Subject: AB/81/18/DOC - 11 Eagle Brewery Yard

The Conservation officer has made the following comments on your application:

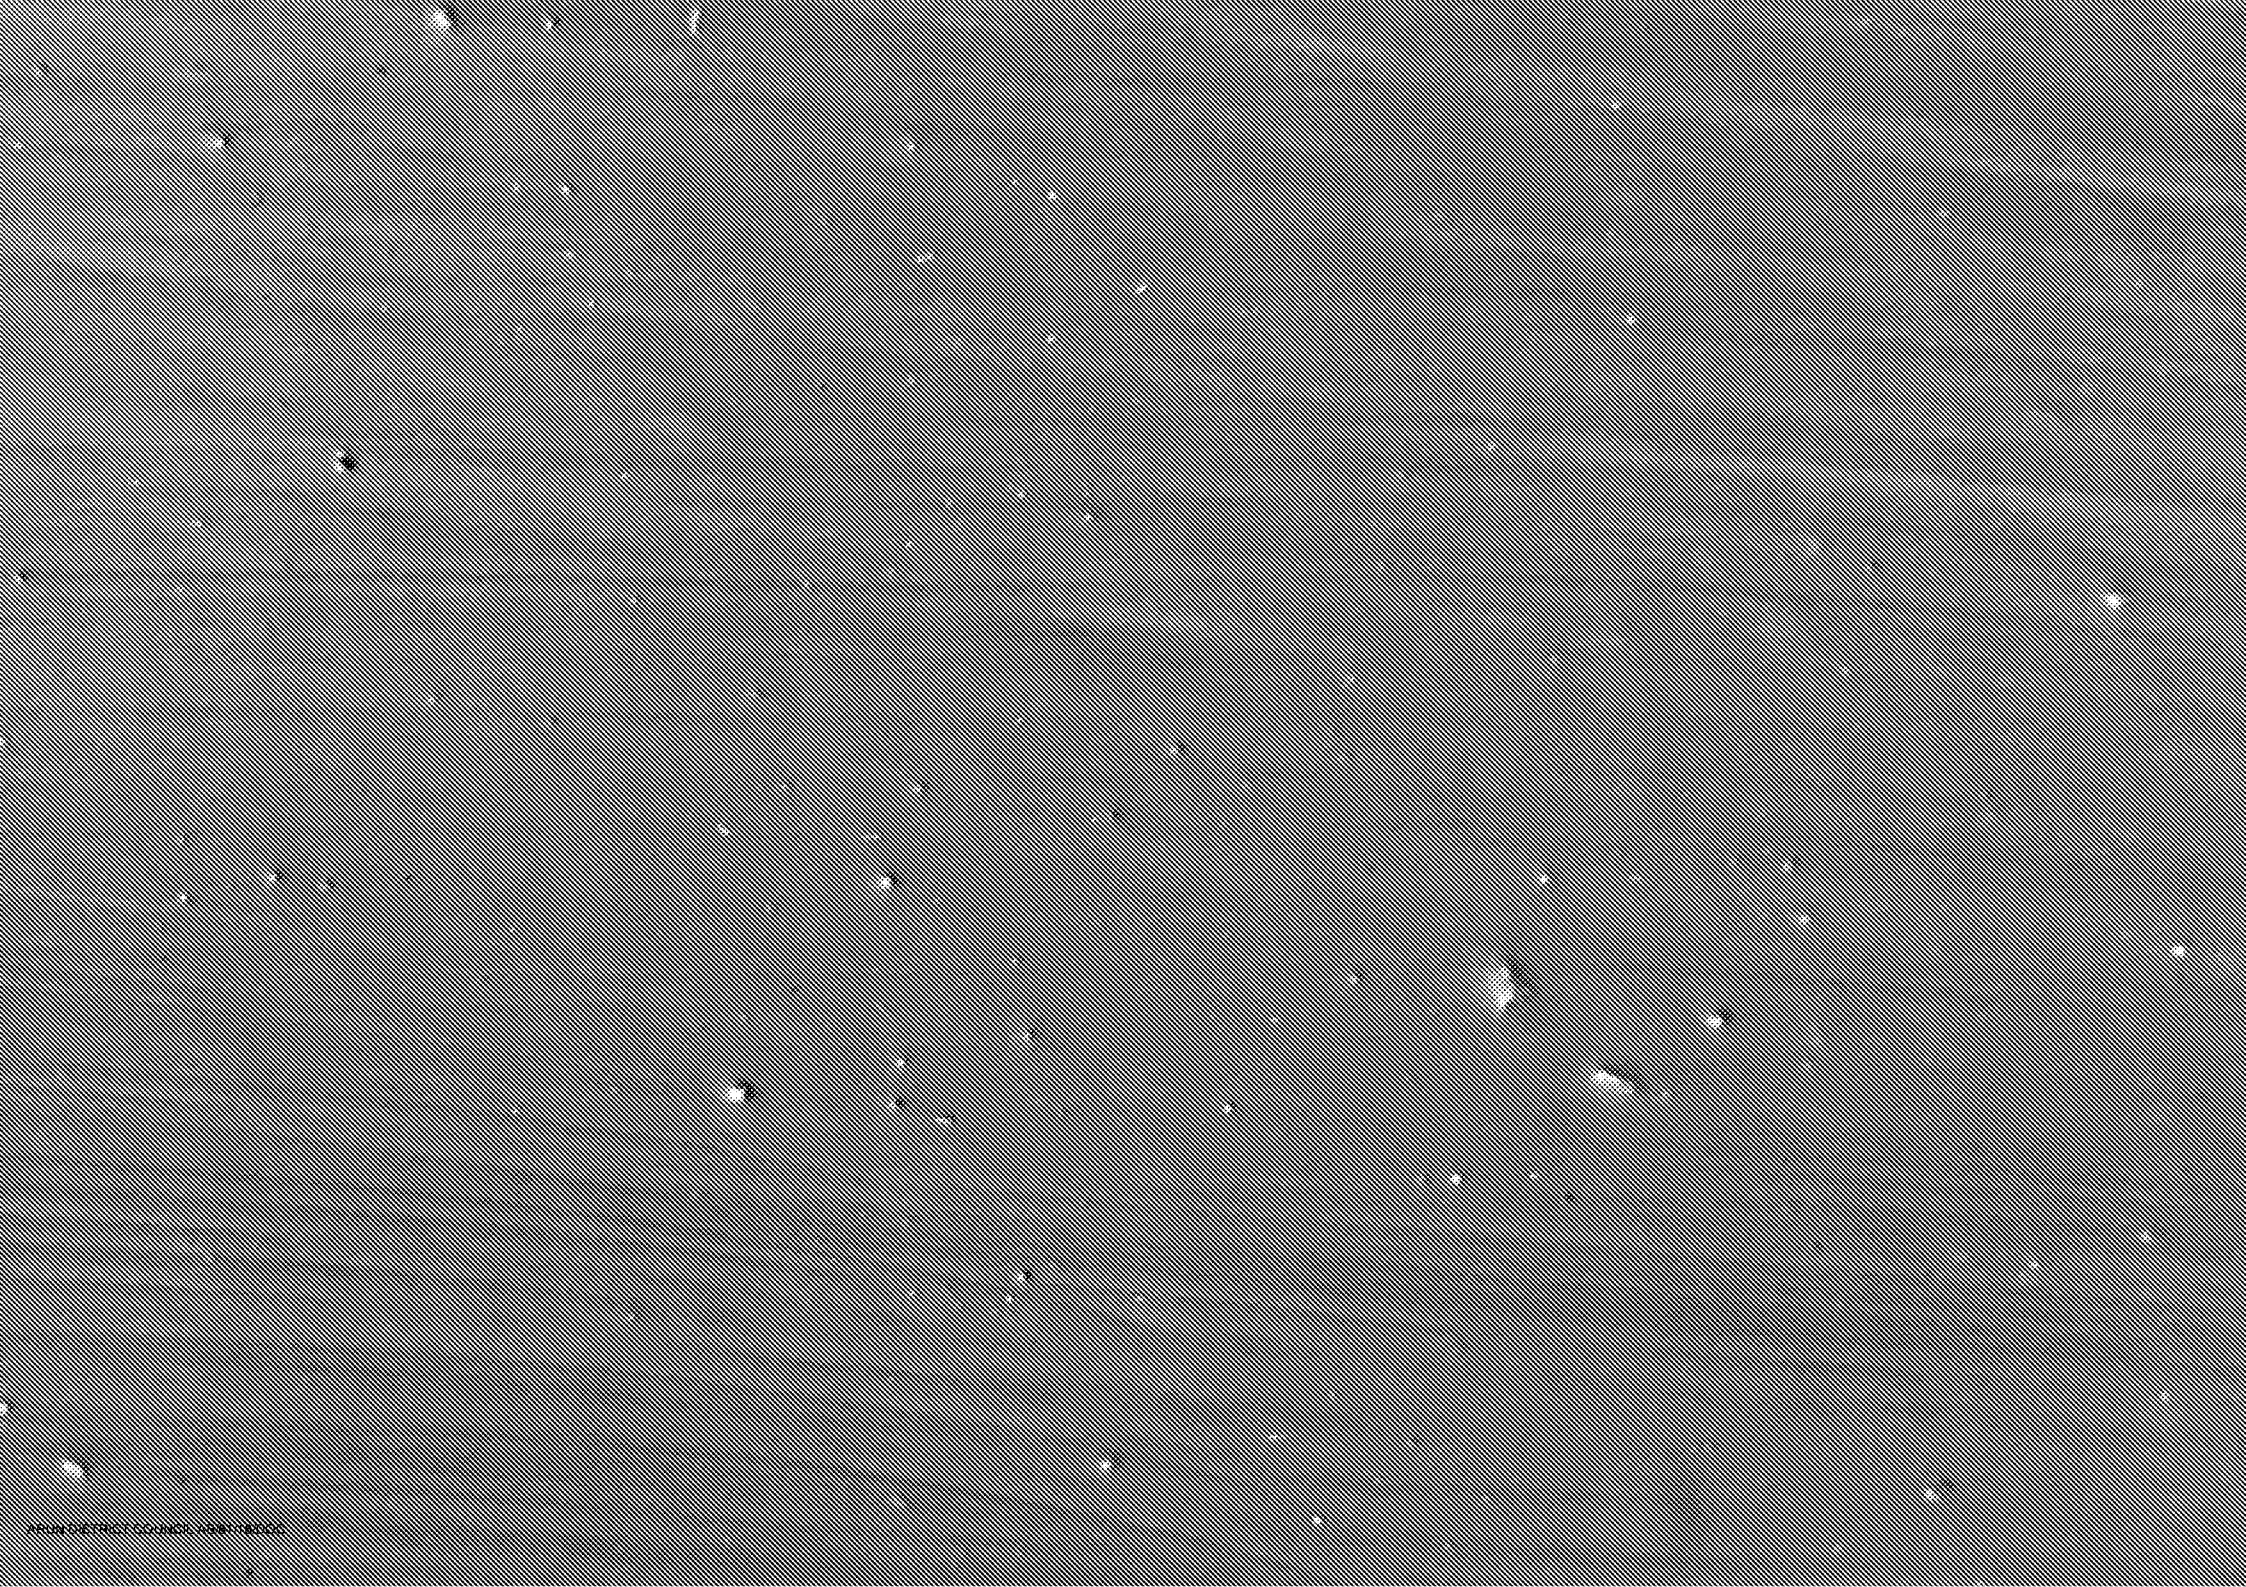
'I note that the application relates to the provision of a new gate to the rear of the property in a former opening. The application included a picture of the proposed style of the gate, which it is assumed was used to determine it. I note that the current application includes a description of how the gate will look. The concept of a solid gate is supported, however no picture has been provided as to its exact appearance. Further, it is not clear what the handle will look like, or what the exact colour will be (is it dark blue?) such information will be needed, even if it is in the form of a photograph with relevant information?
